# CITY OF ALBUQUERQUE

**Re: Townhouses for Buchanan**  
**1106 Griegos Rd NW**  
**Traffic Circulation Layout**  
Engineer's/Architect's Stamp **10-07-2018 (F14D058A)**

Based upon the information provided in your submittal received 10-19-2018, the above referenced plan cannot be approved for Building Permit until the following comments are addressed:

TRAFFIC CONTROL LAYOUT
Scale: 1" = 20'-0"

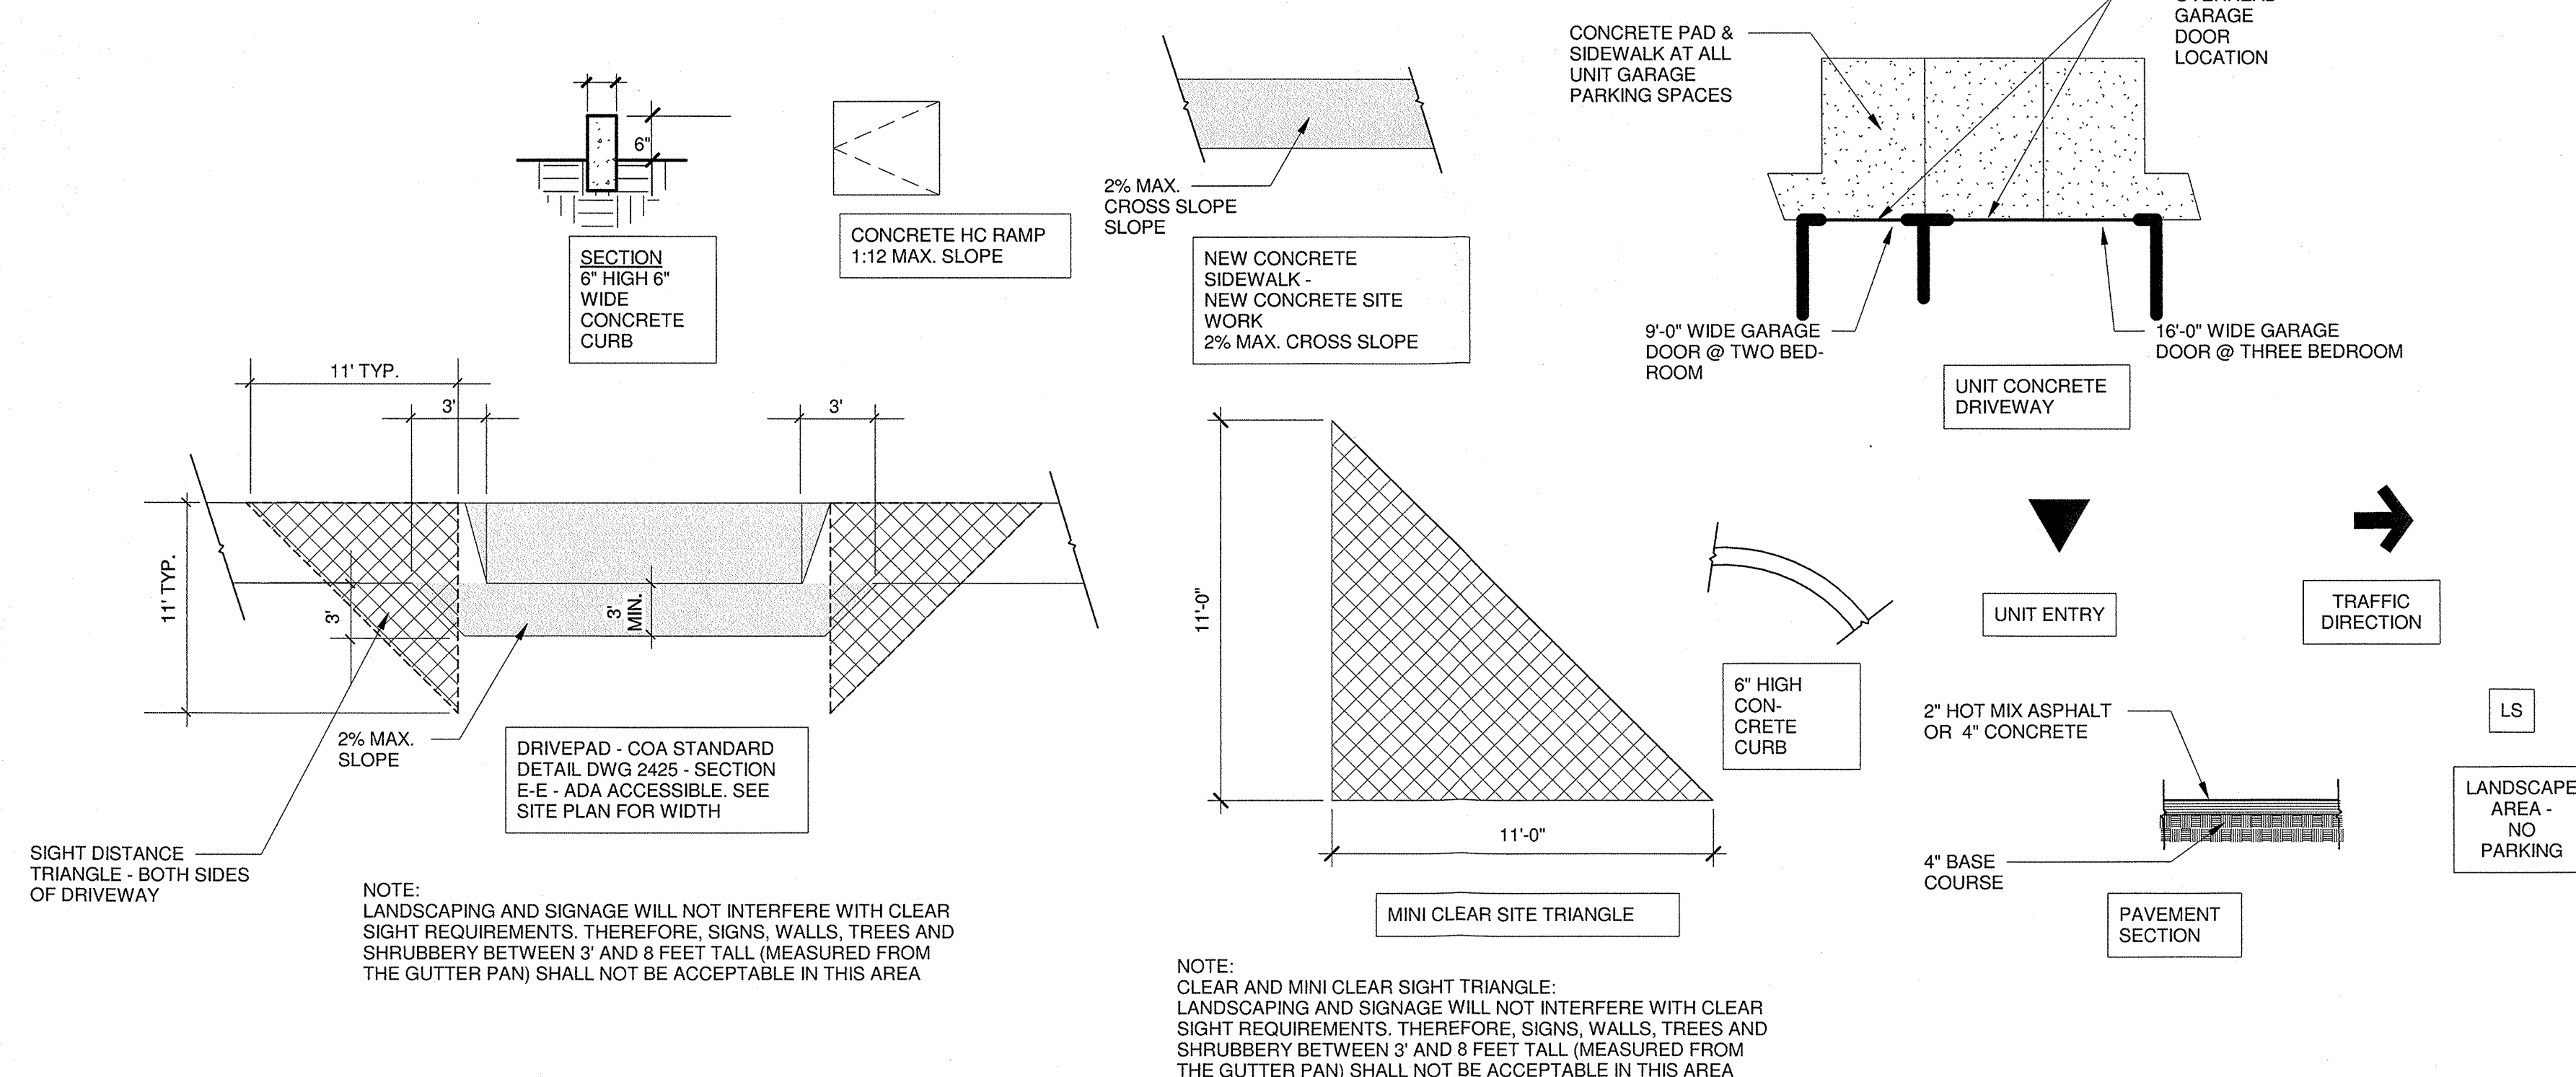
1. Please remove the recycle and refuse carts from right of way and place it on-site.
2. The width of the new drive pad should be 25 feet.
3. Extend the concrete curb all along the parking space as shown in the picture.
